PLANNING CONSULTATION RESPONSE

Application No	2025/0610
Proposal	Development of five residential dwellings and associated infrastructure
Address	Vernon House, Yews Lane, Kendray, Barnsley, S70 3LJ
Date of Consultation Reply	12 th August 2025
Consultee	Highways DC

Title
SITE ACCESS & PROPOSED LEVELS

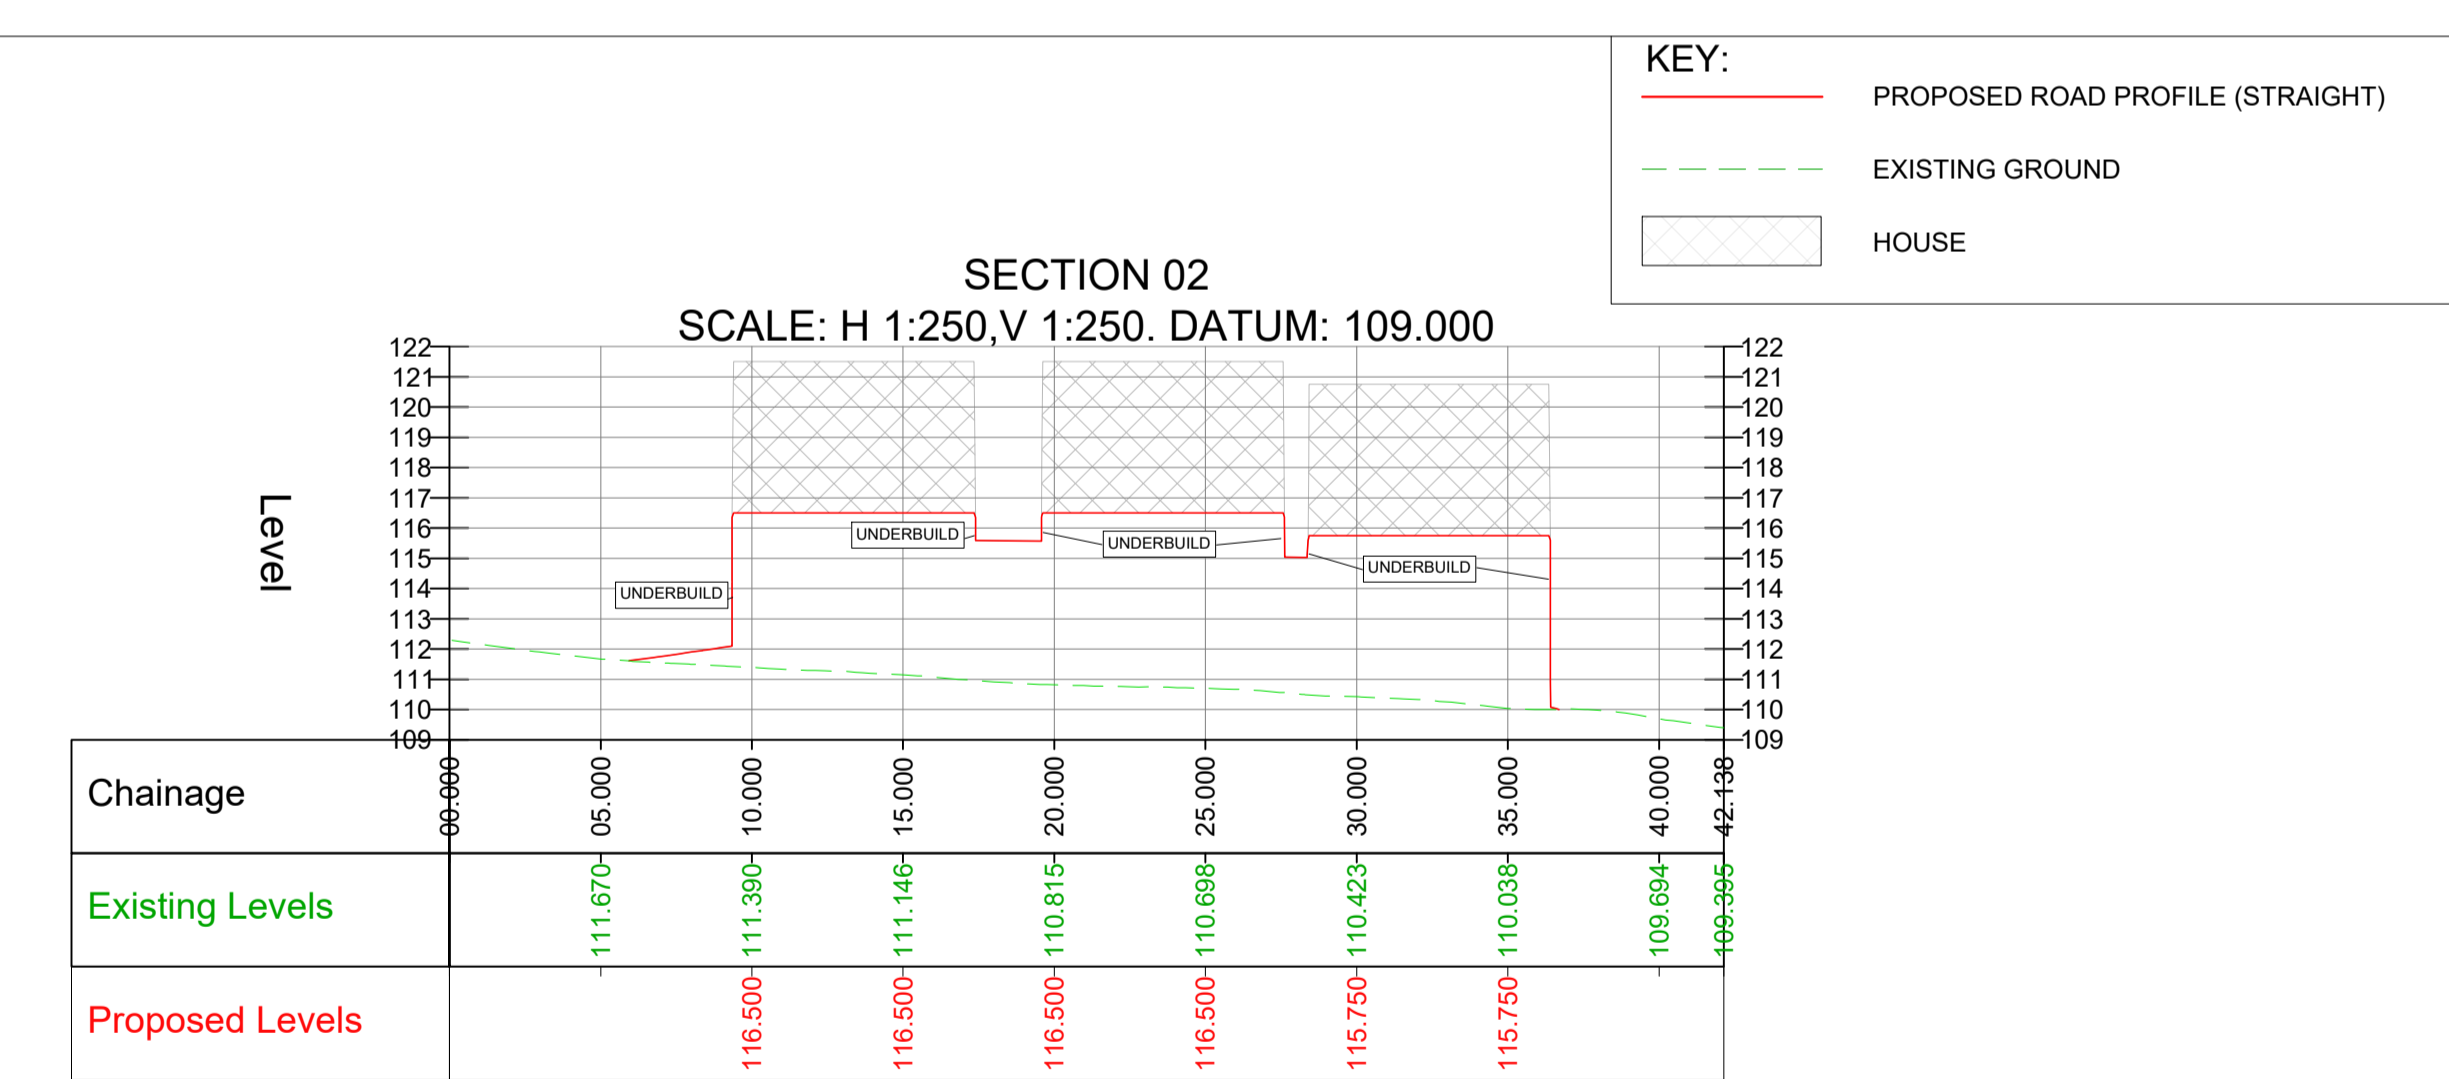
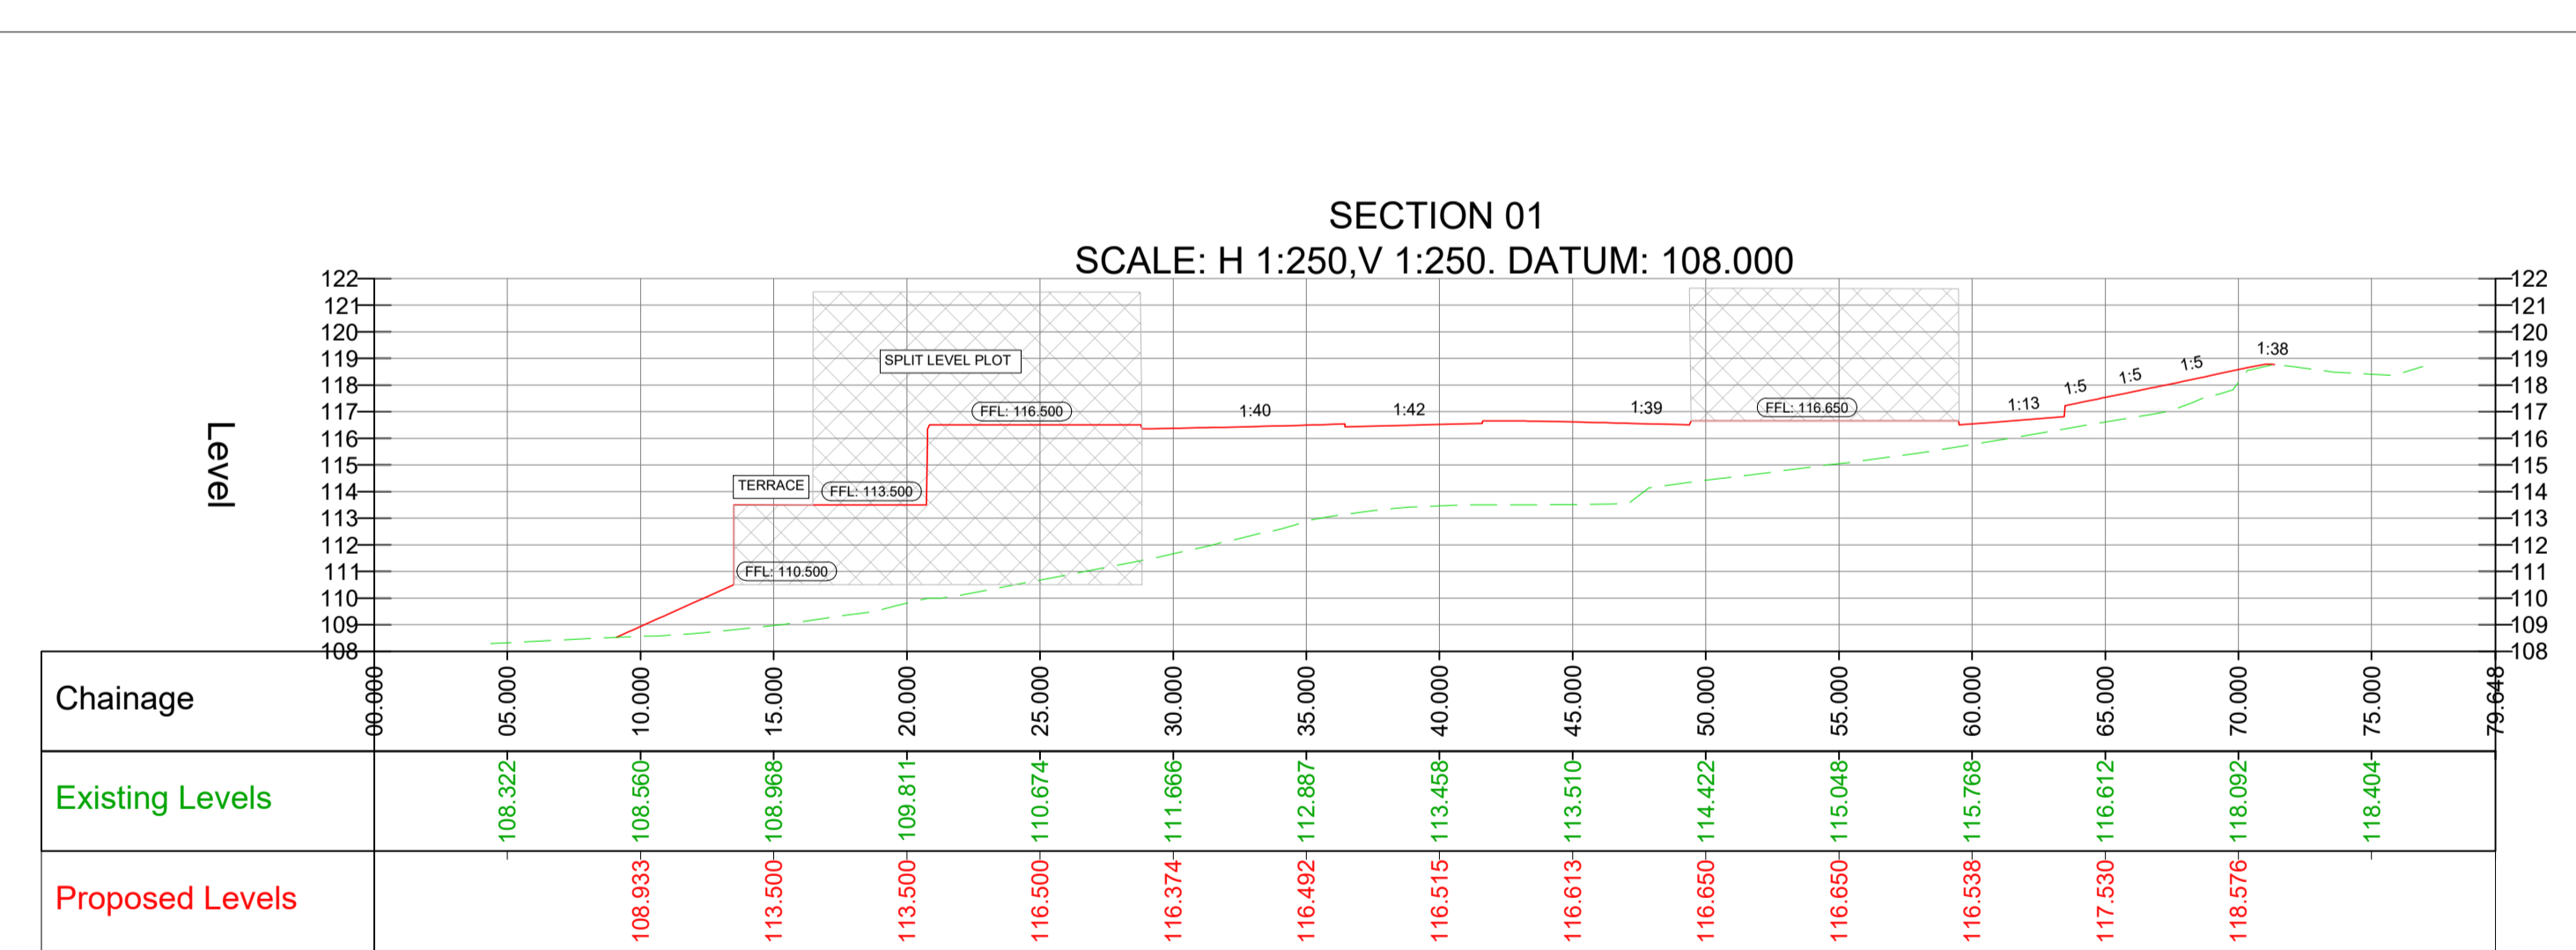
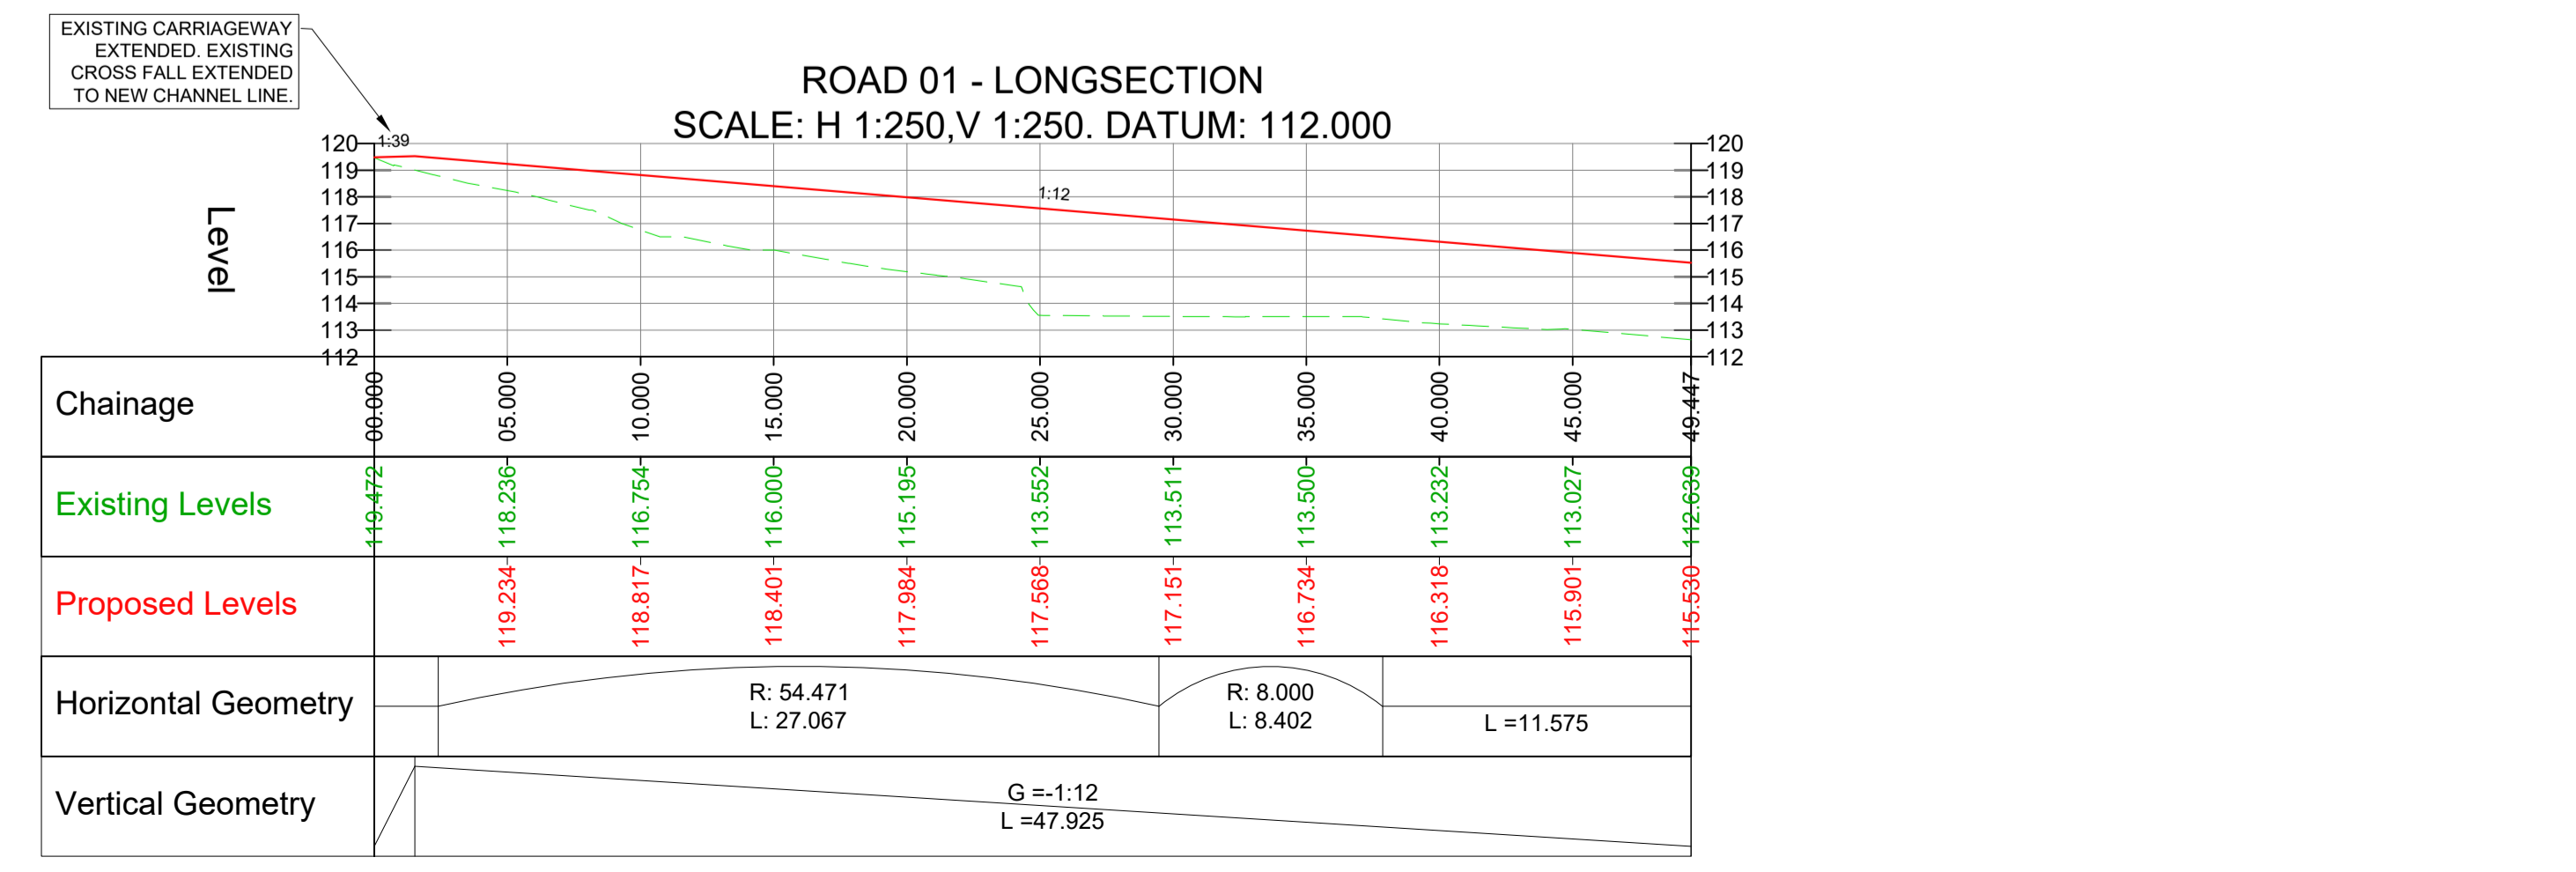
The proposed site access is shown to have a gradient of 1:8, this exceeds the maximum permitted gradient of 1:12.
